CGS Unique No.: EP-26-0090_1 Church at Bent Grass Meadows

El Paso Project ID: SF268

Description: Rezone from RR5 and PUD to Commercial Service.

At your request (email dated April 30, 2026), the Colorado Geological Survey has reviewed the Church at Bent Grass Meadows Final Plat submittal. With this referral, we received the Letter of Intent (HR Green, April 13, 2026), Final Plat (Compass Surveying & Mapping, LLC, April 3, 2026), Geotechnical and Pavement Design Report (Entech Engineering, Inc., November 11, 2024), and other documents.

FINAL PLAT
CHURCH AT BENT GRASS MEADOWS

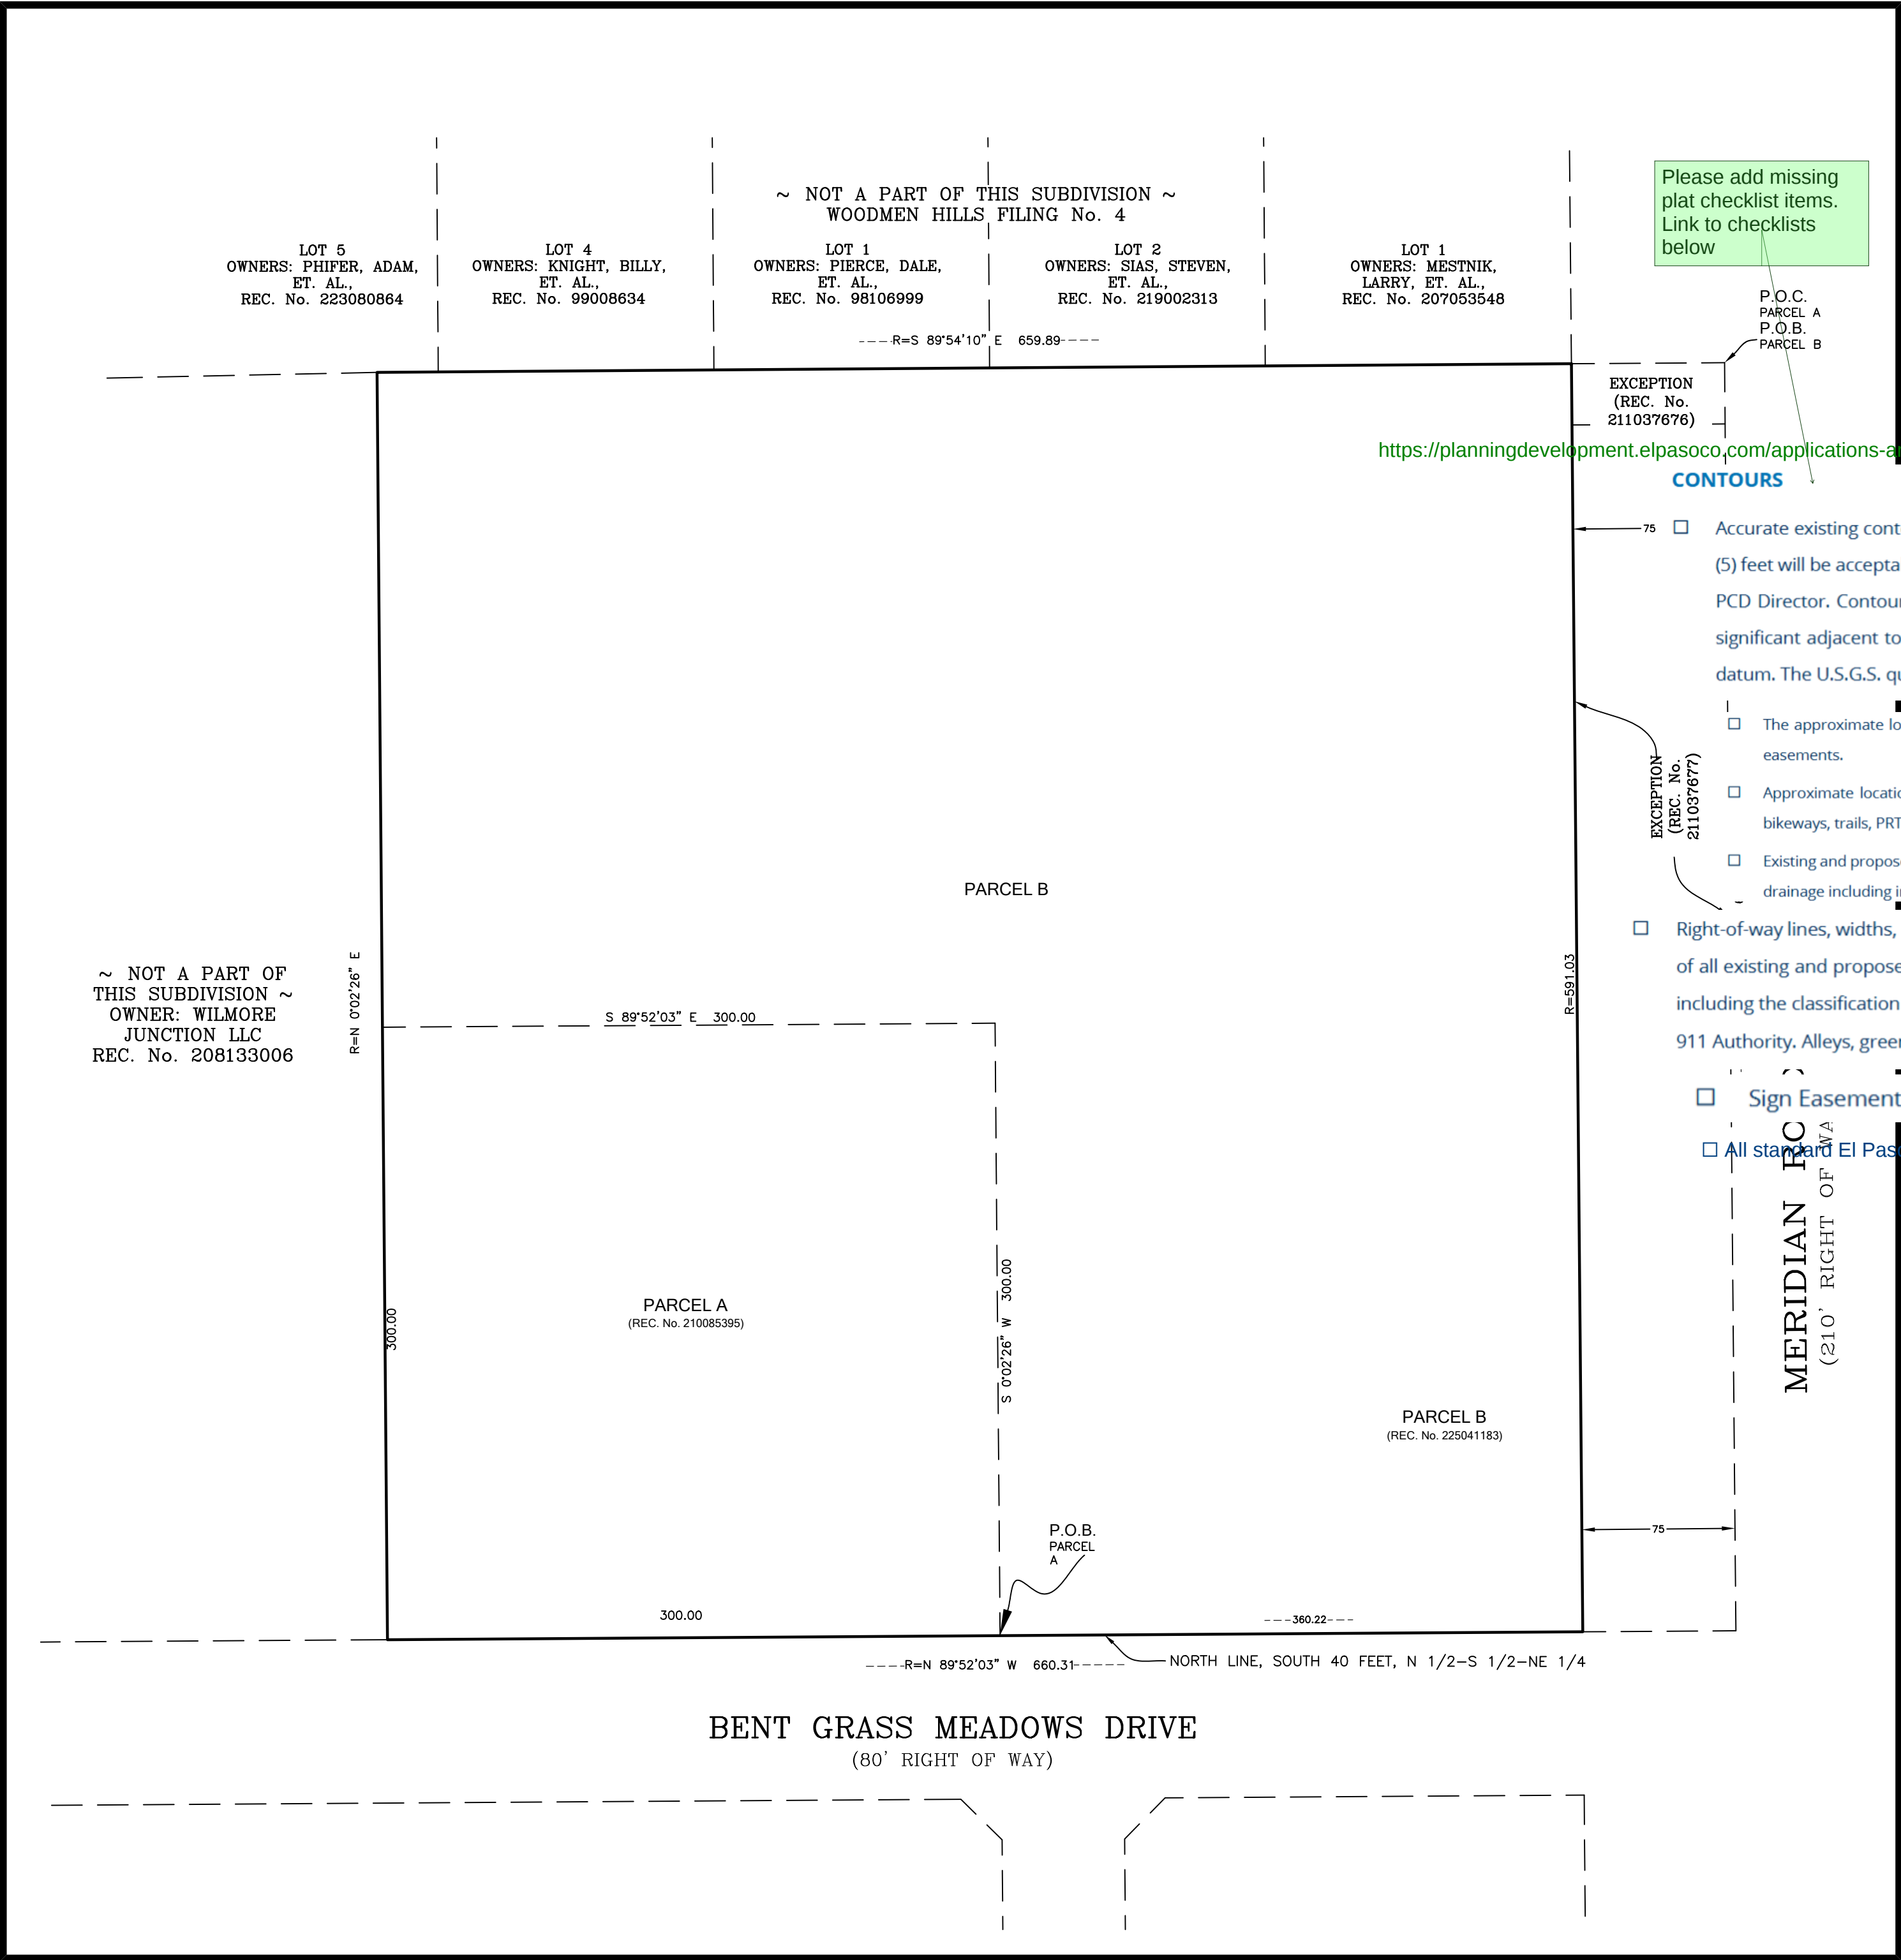
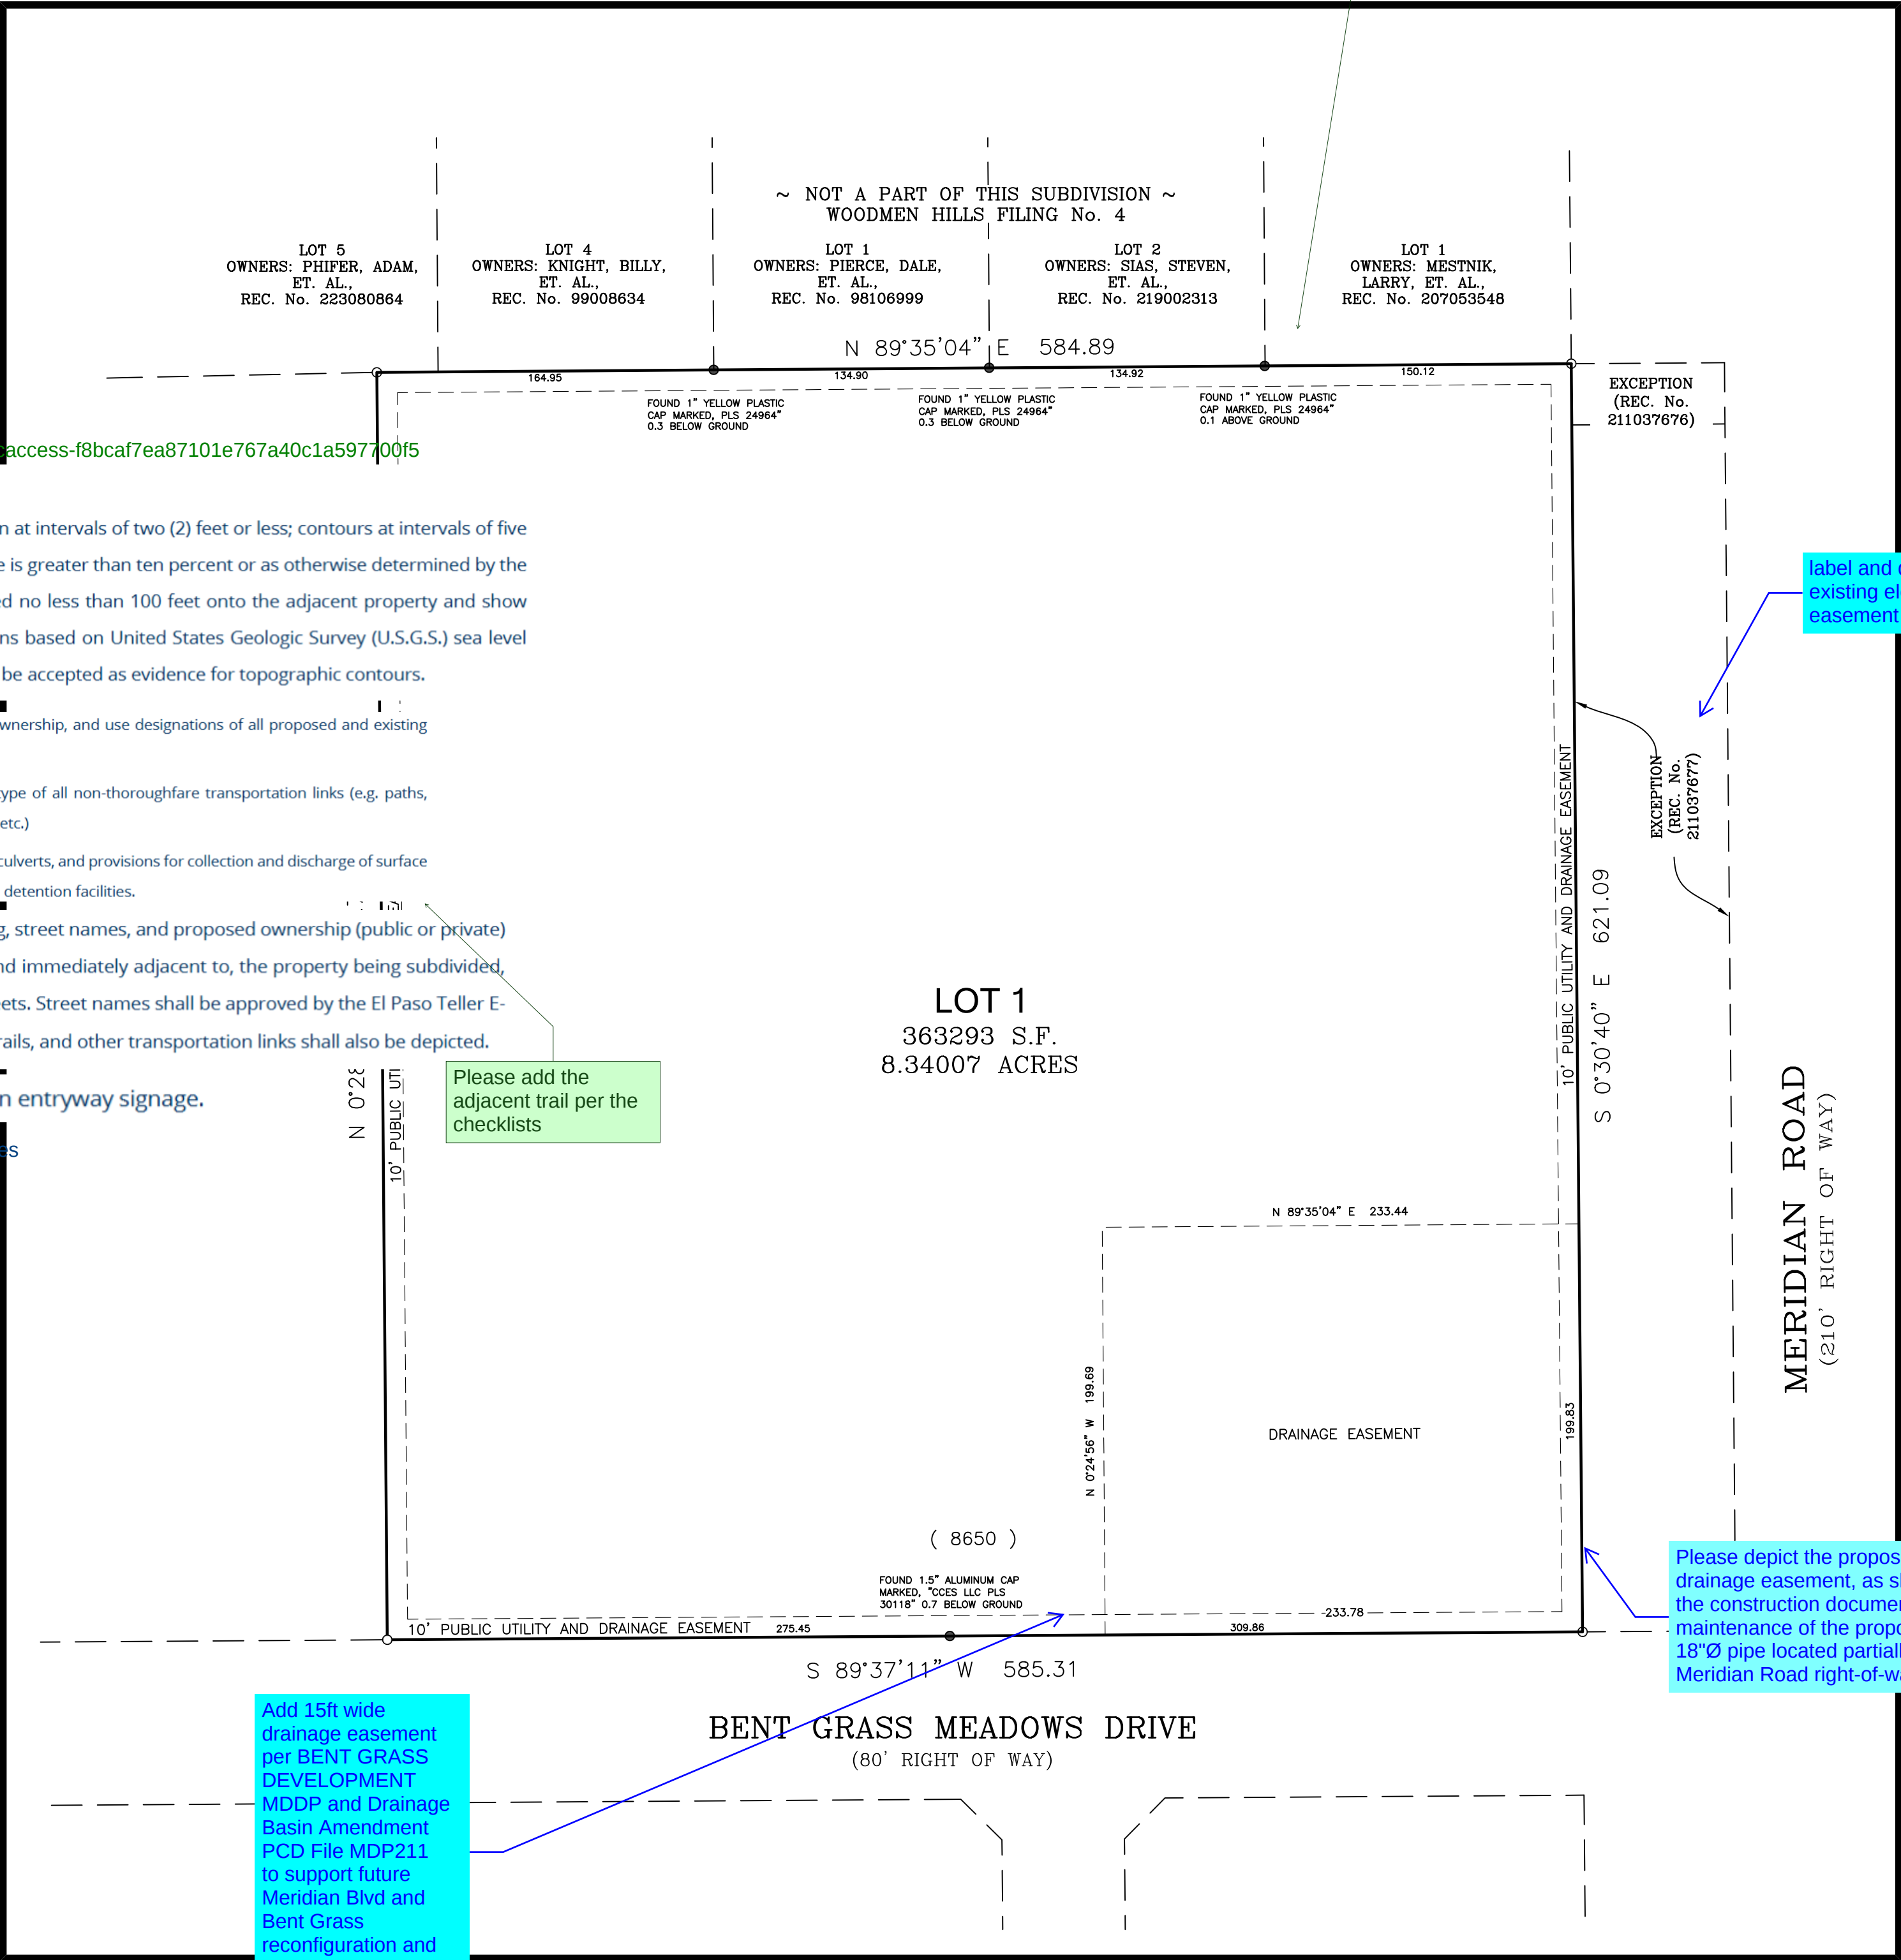
2. CGS recommends that a note be included on the final plat referencing the geologic hazard study and listing the geologic hazards associated with the site.
